Summary of Written Representations from Suffolk Wildlife Trust

Submitted for Deadline 1: 26th February 2026

Application by National Grid Electricity Transmission for the Norwich to Tilbury Project

Planning Inspectorate Ref: EN020027

Document: 7.4 Outline Landscape and Ecological Management Plan
Appendix F - Bird Diverter Locations

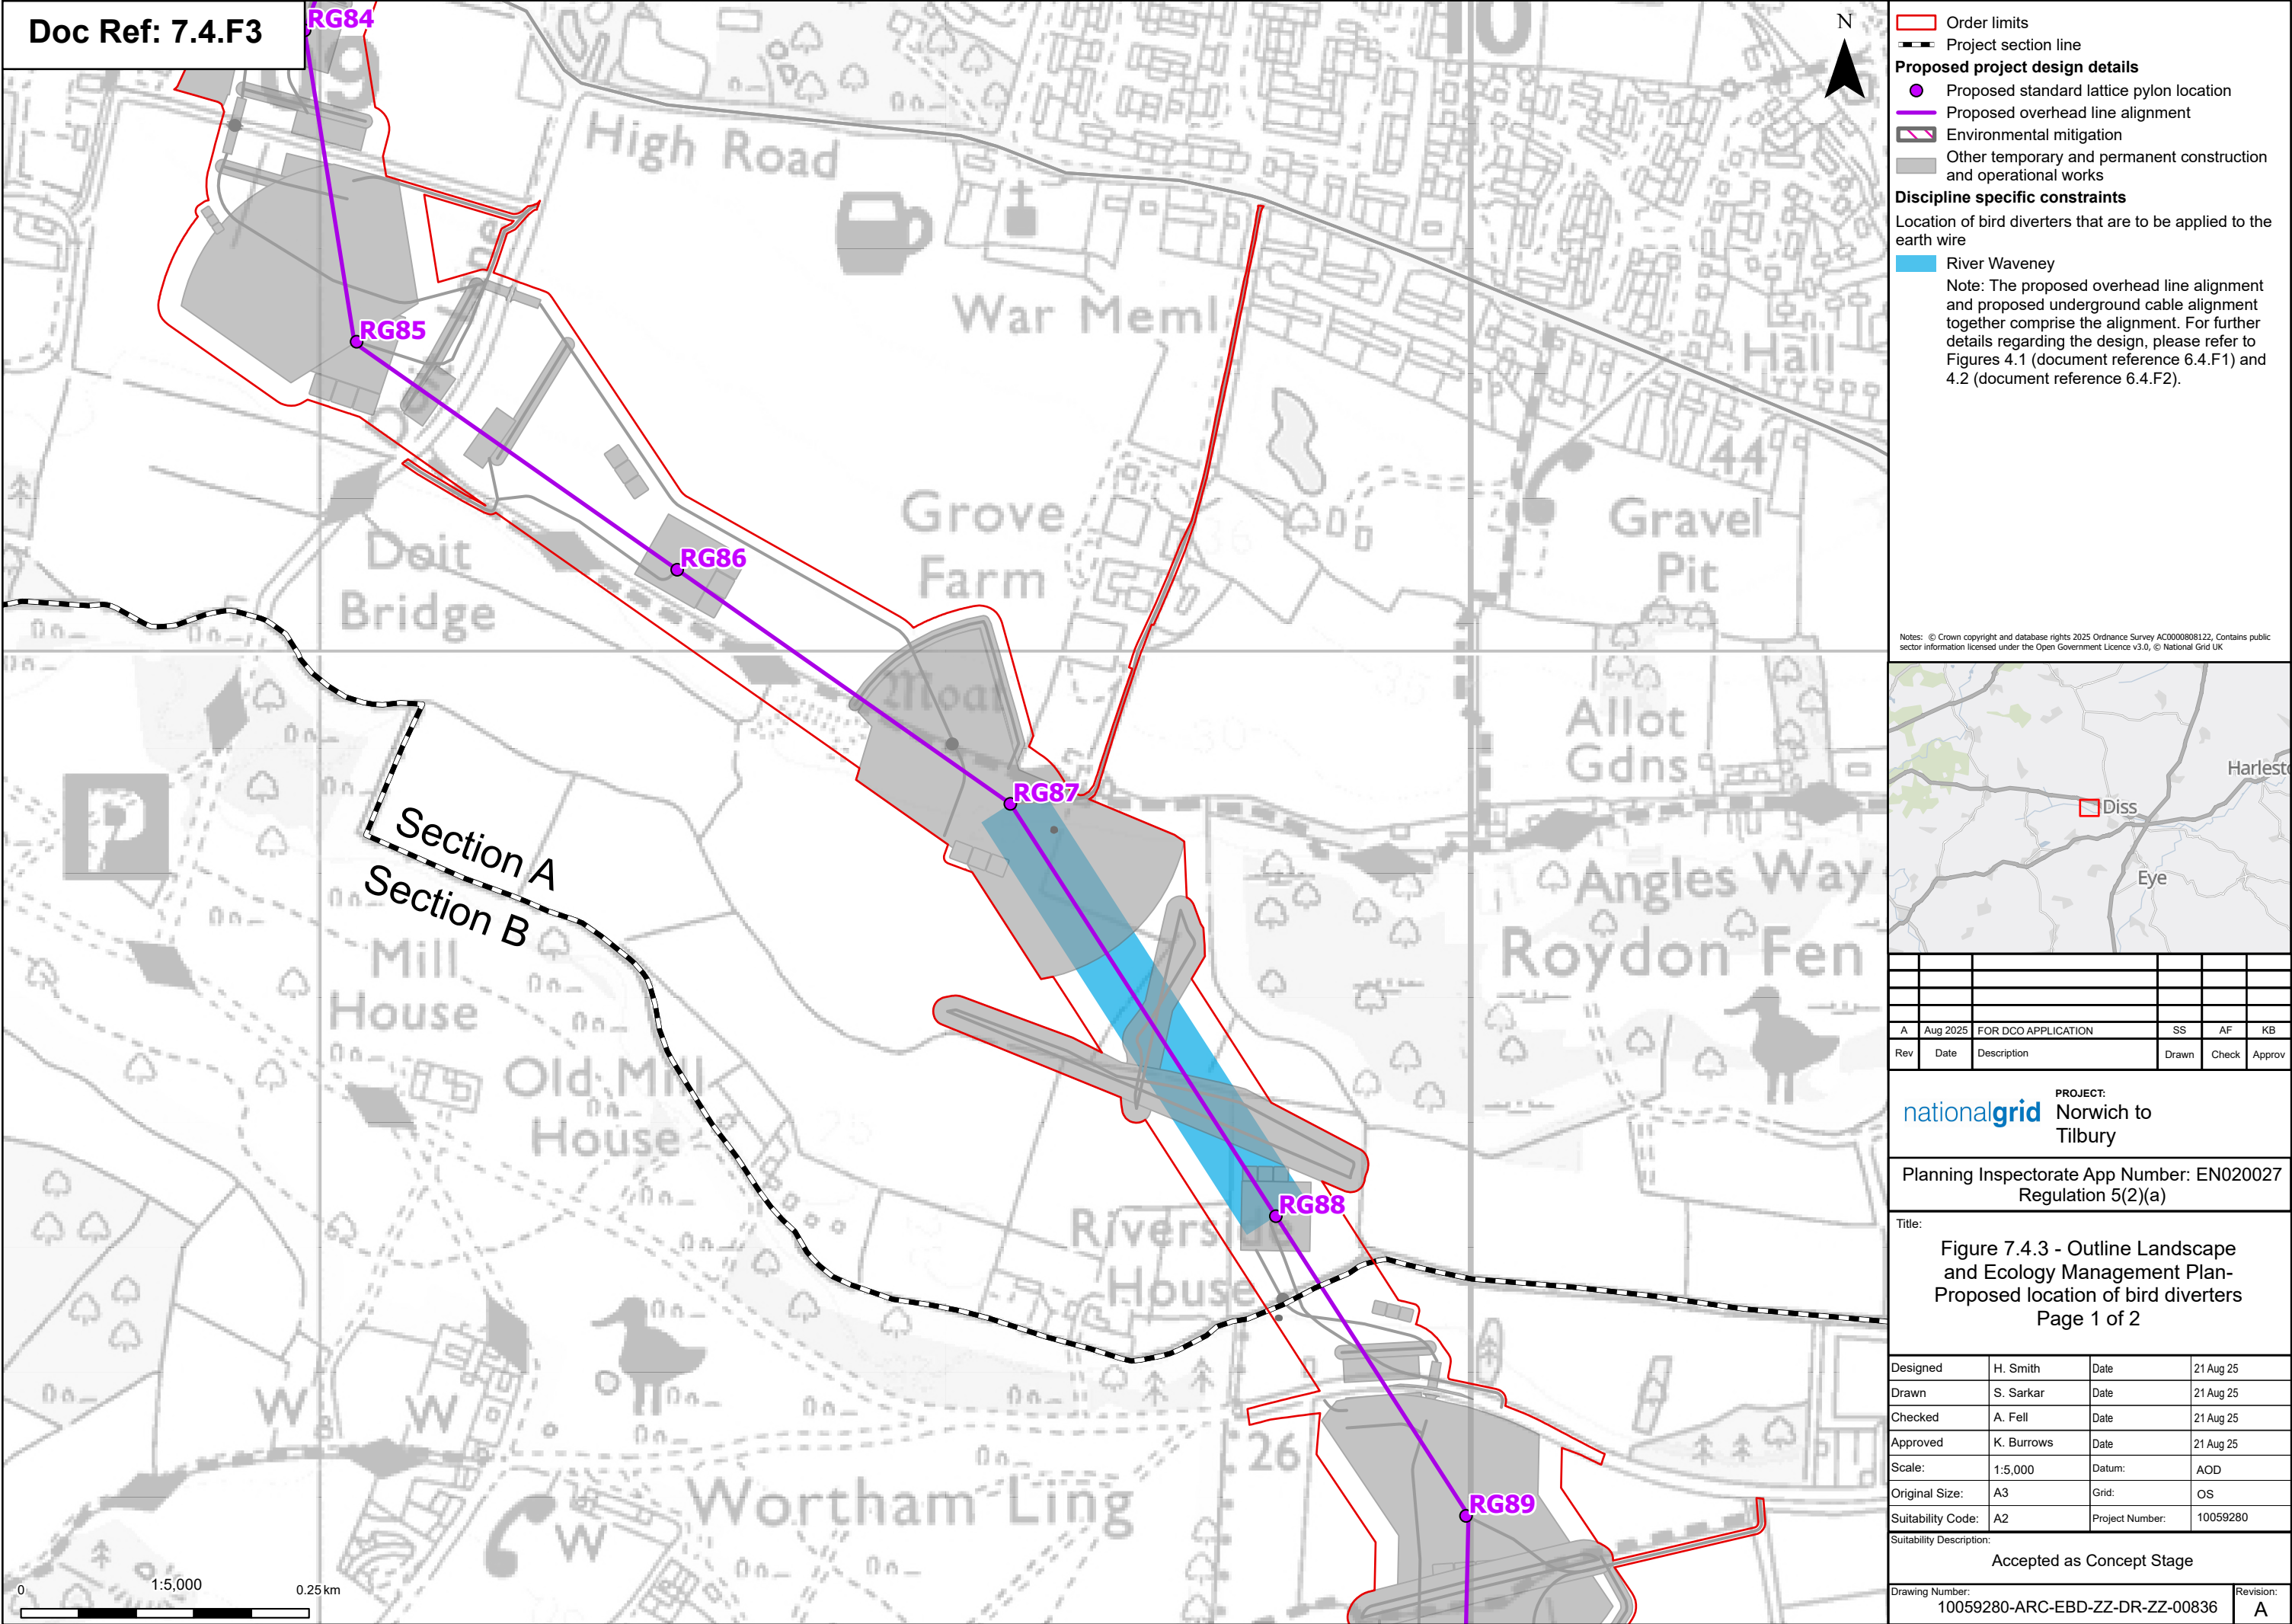
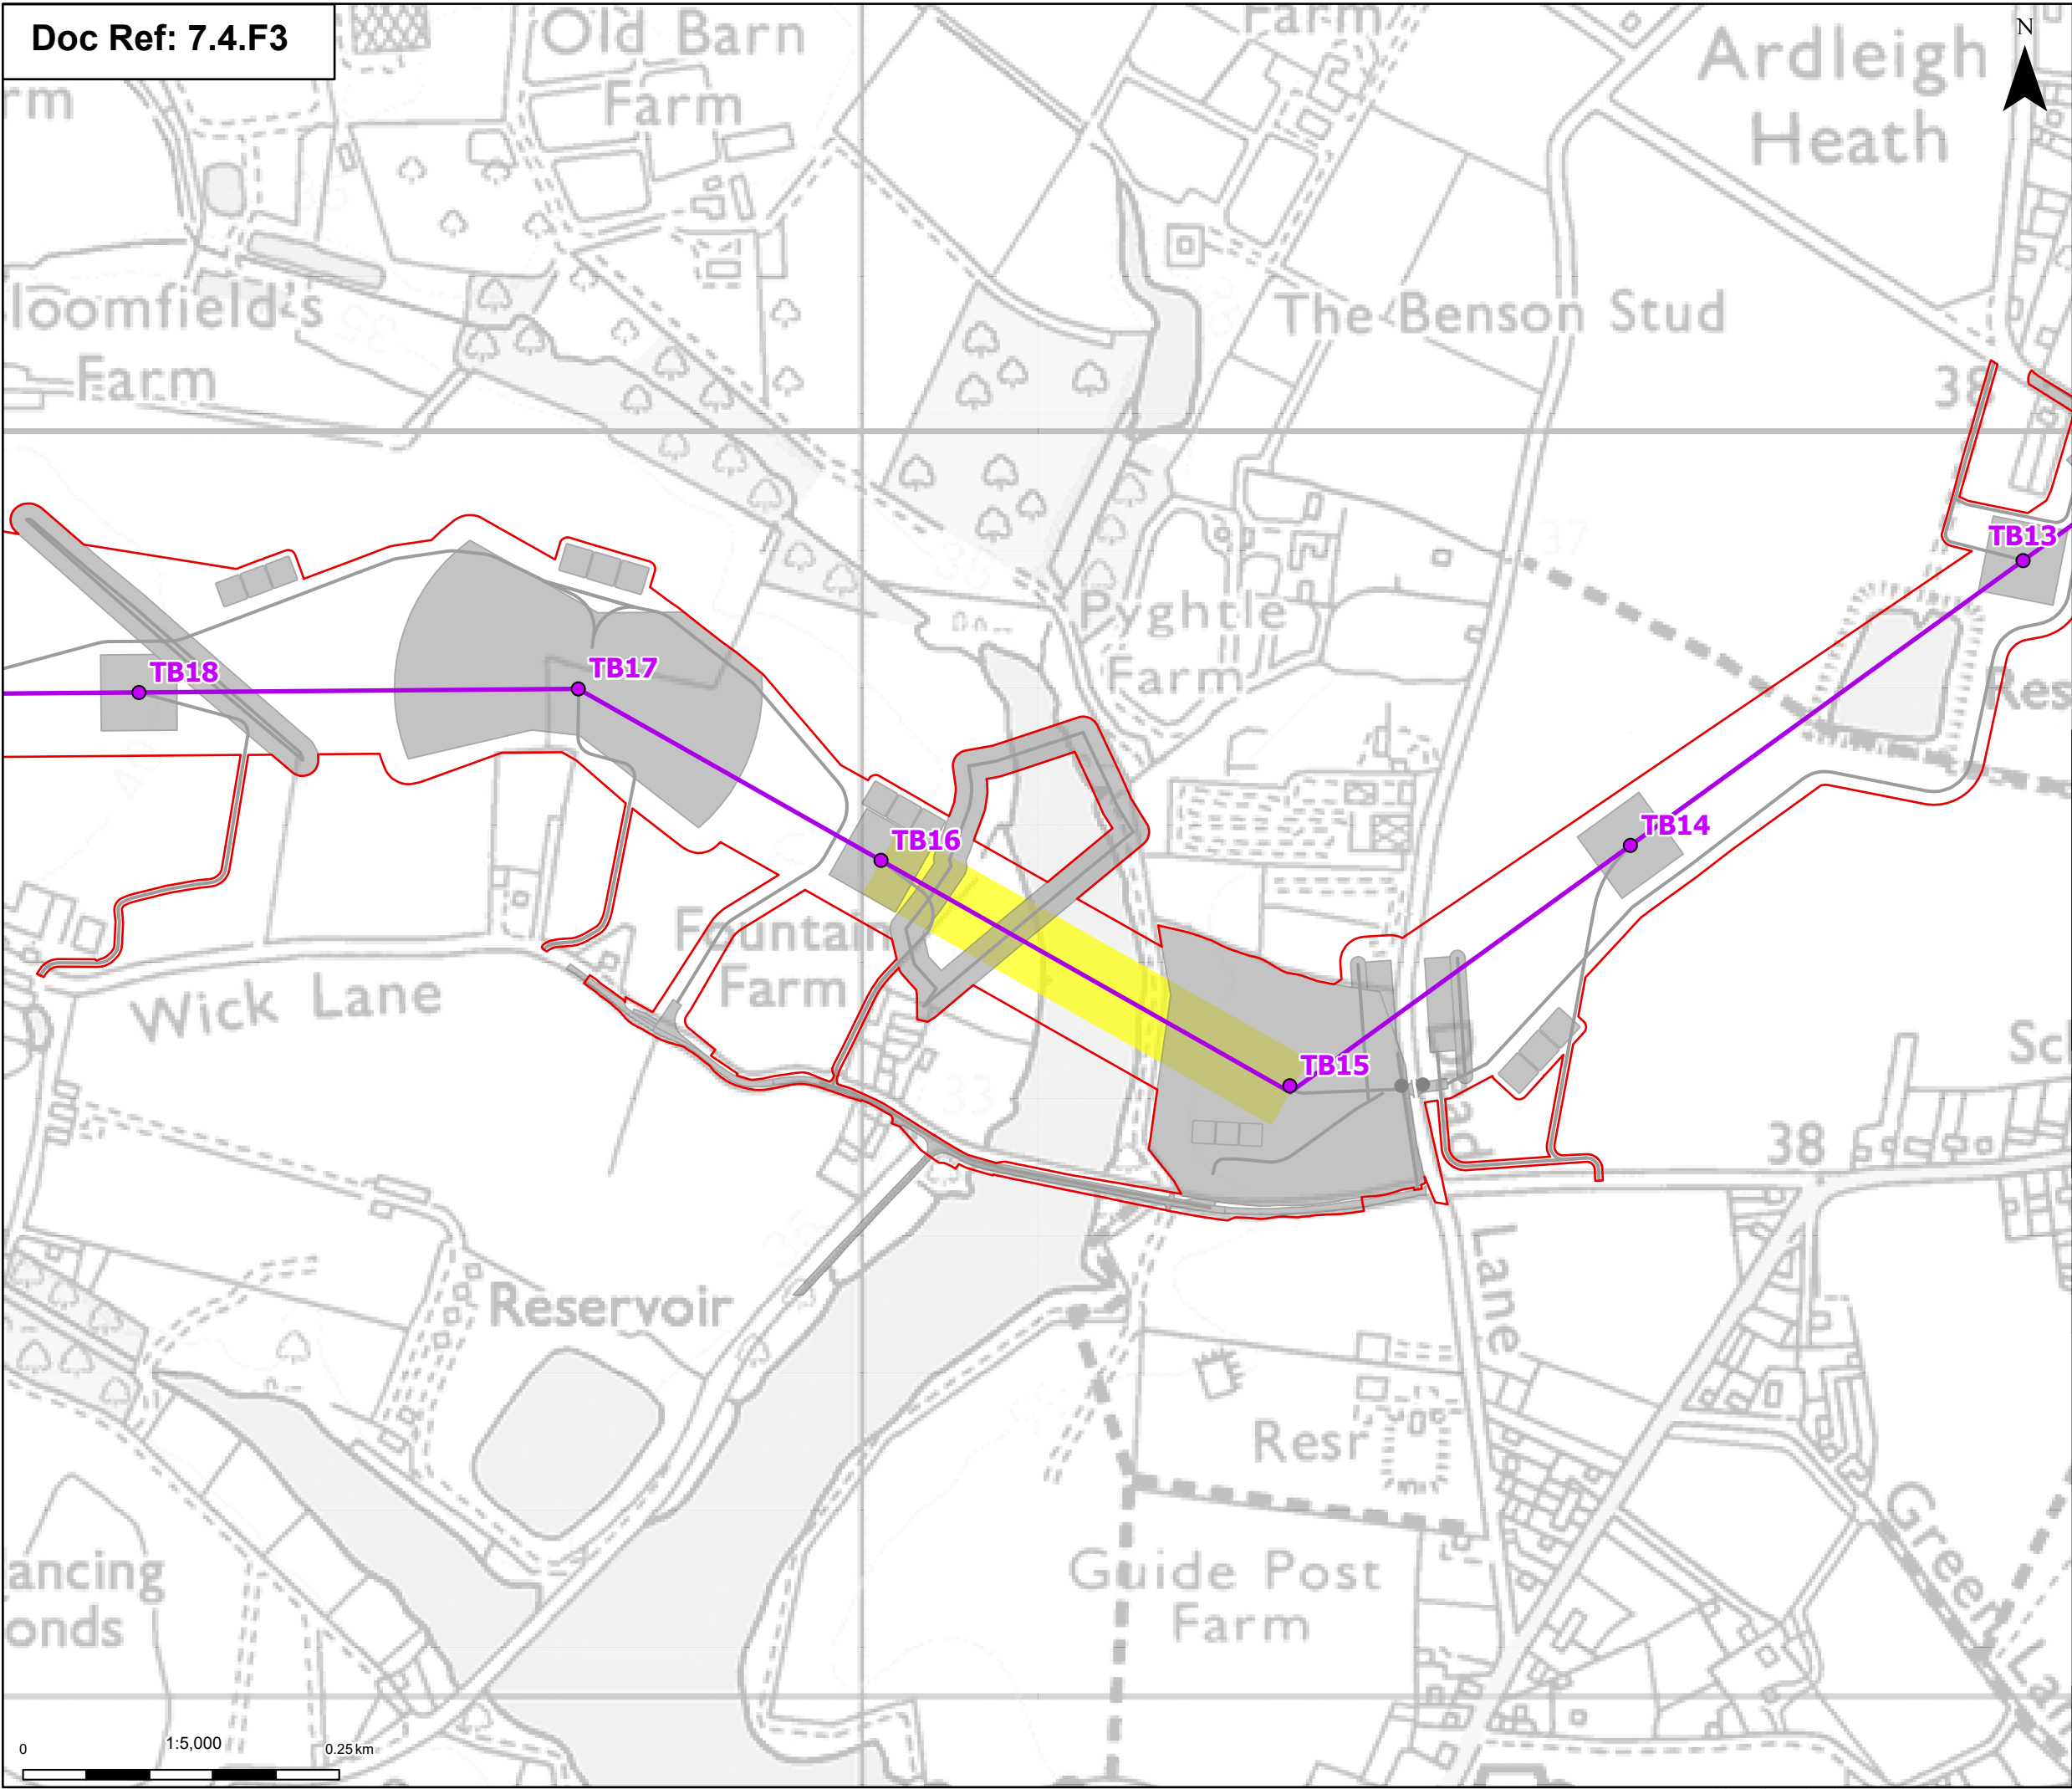
The provided documents do not state the distance apart at which diverters will be placed; however, a typical placement is at intervals of 10m. Suffolk Wildlife Trust suggest that monitoring of the effectiveness of this mitigation is undertaken, with distance between markers reduced if deemed necessary. Monitoring may also suggest that the location where markers are installed is extended to the south, beyond Pylon RG88 and to the south of the River Waveney itself, where they are not currently proposed.
